Our Case Number: ABP-314724-22

Re: Railway (Metrolink - Estuary to Charlemont via Dublin Airport) Order [2022]

RE: Railway (Metrolink–Estuary to Charlemont via Dublin Airport) Order 2022

Earl Court Apartments, Adelaide Road

ML1-JAI-RTA-ROUT_XX-DR-Y-02027

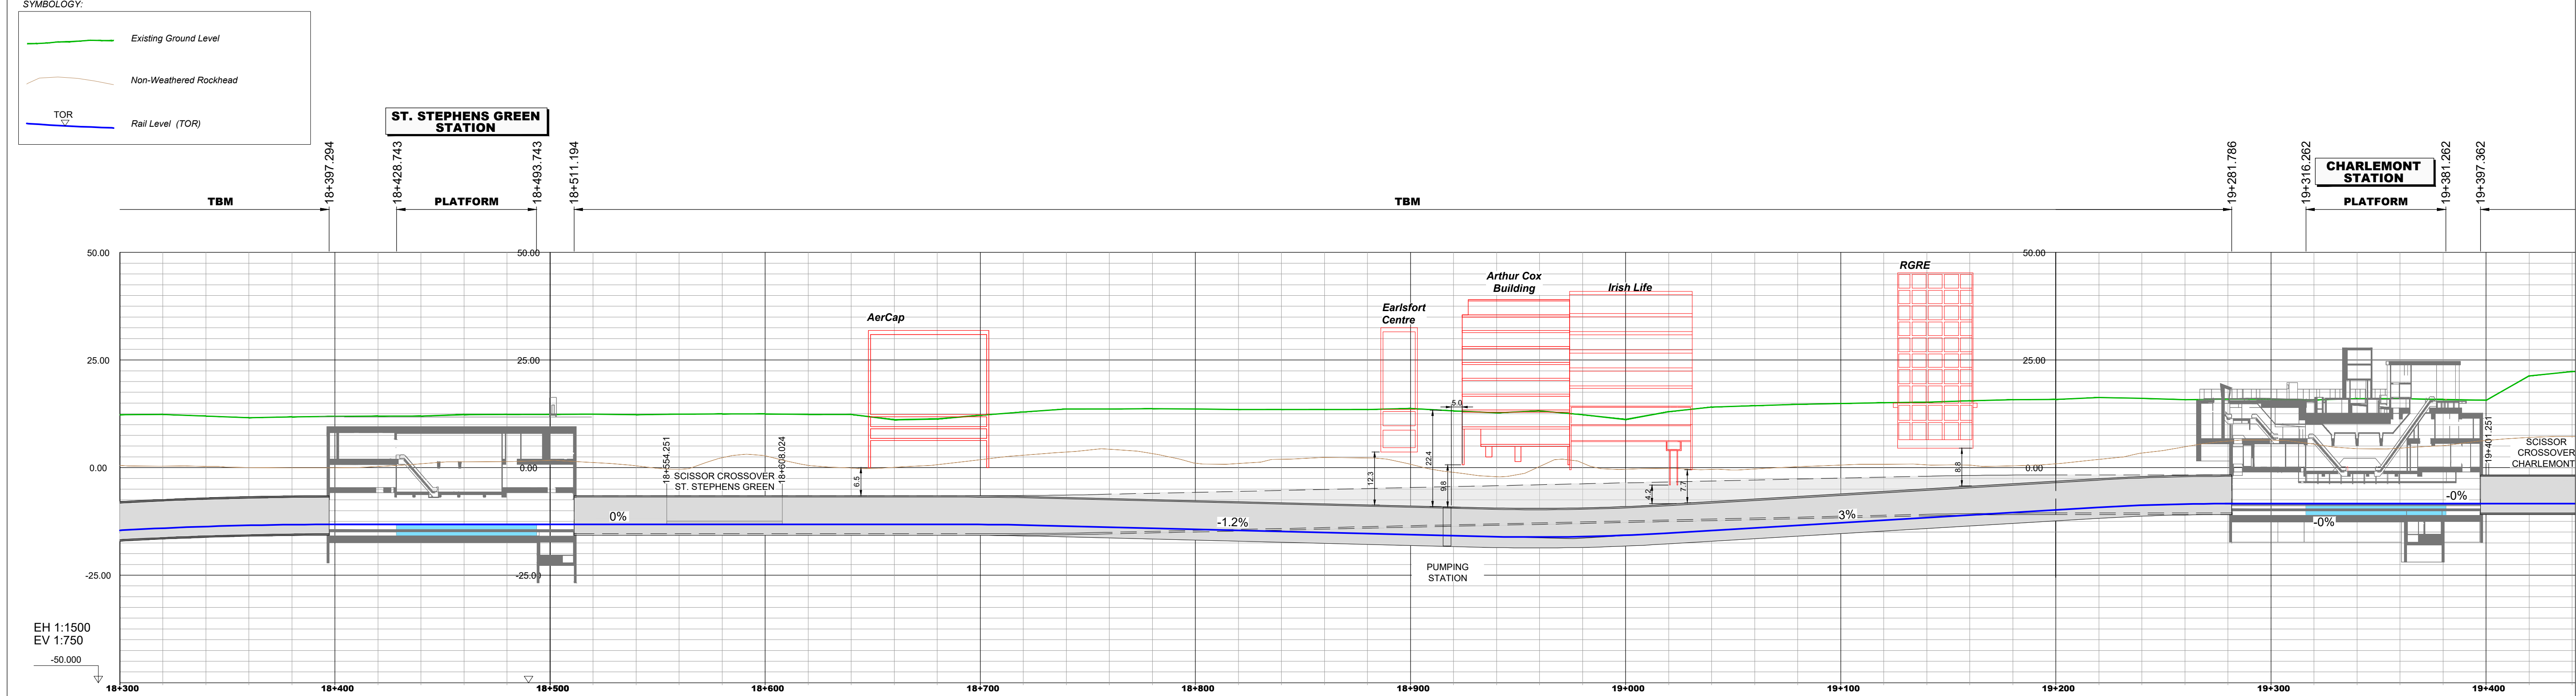
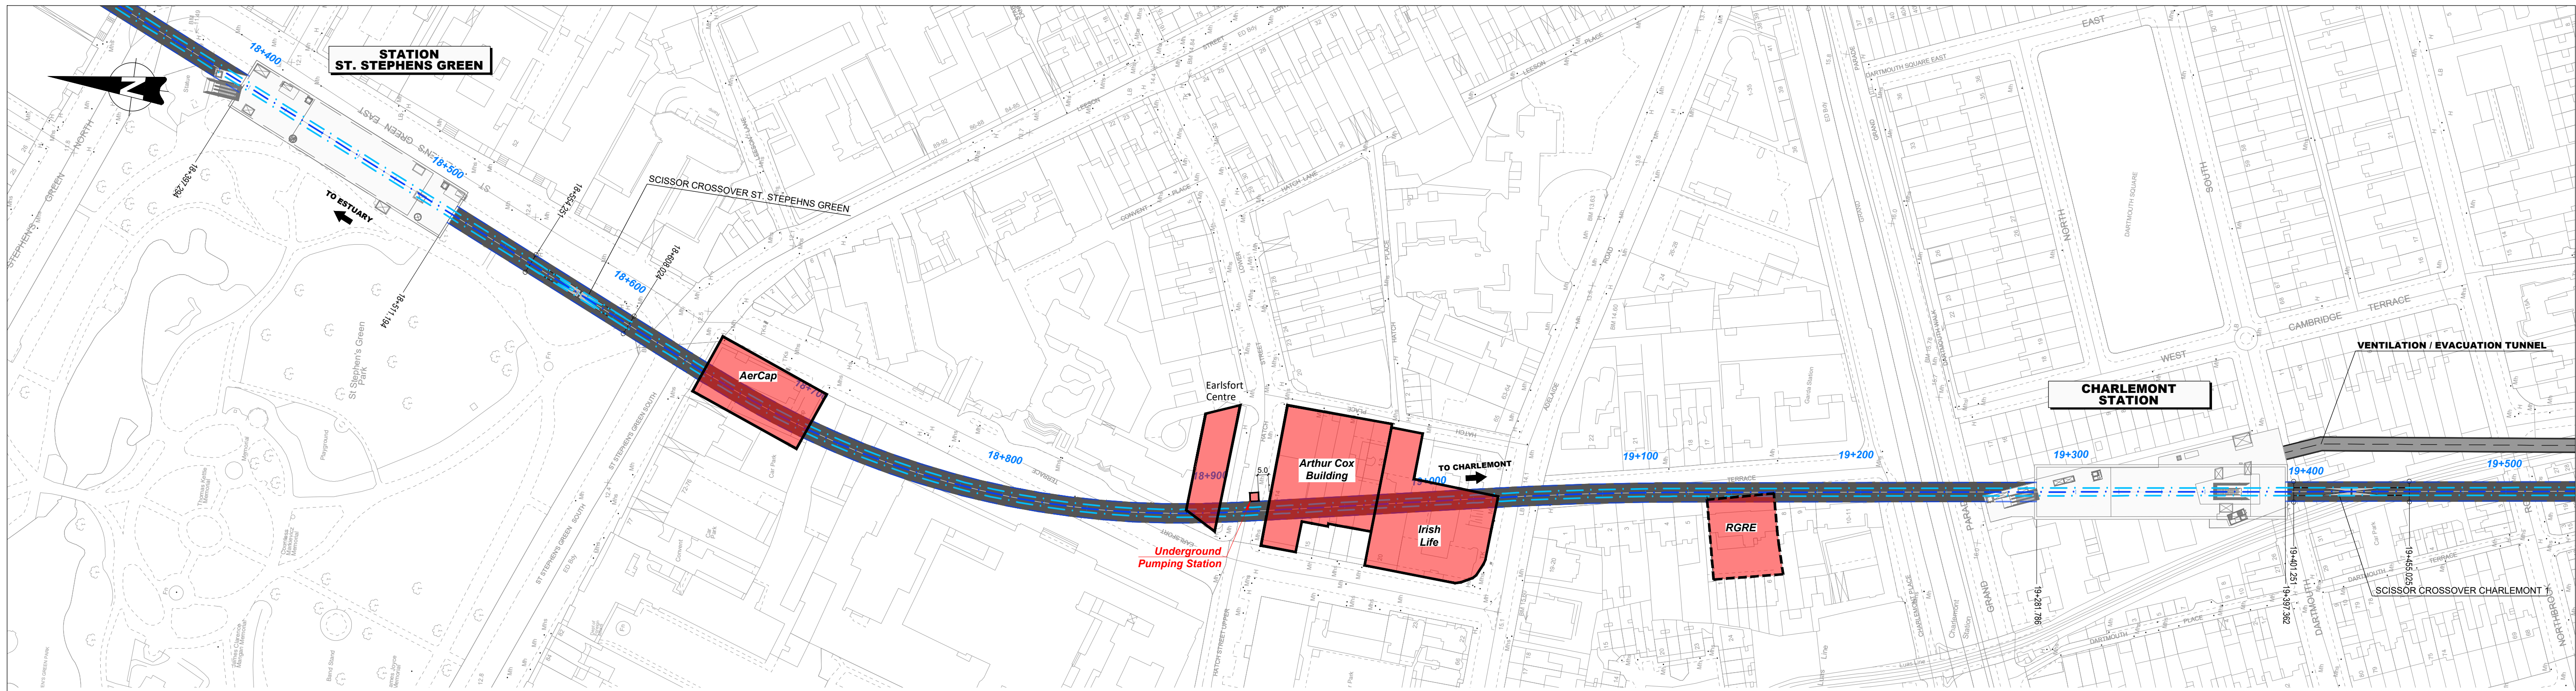
- (a) MetroLink does not cause structural damage to the foundation system supporting our Clients' building, which comprises strip and pad foundations founded in boulder clay.
- (b) MetroLink does not cause structural damage to our Clients' building at any level.
- (c) MetroLink does not cause damage to the finishes of our Clients' building.
- (d) MetroLink provides the necessary vertical and/or horizontal clearance between the existing basements and the tunnels.
- (e) We enclose a copy of a drawing EARL-WMS-ZZ-ZZ-DR-S-21209 prepared by Waterman Moylan for your information and reference. Our Clients' building is located on the south eastern side of the building, as shown by Waterman Moylan. We are showing on that drawing our clients' building.

In summary, our Client requests that the route of the proposed MetroLink tunnels are diverted away from their current proposed location (under our Clients' building) to either below the public carriageway or buildings that will not be damaged or compromised by the presence of the tunnels located under.
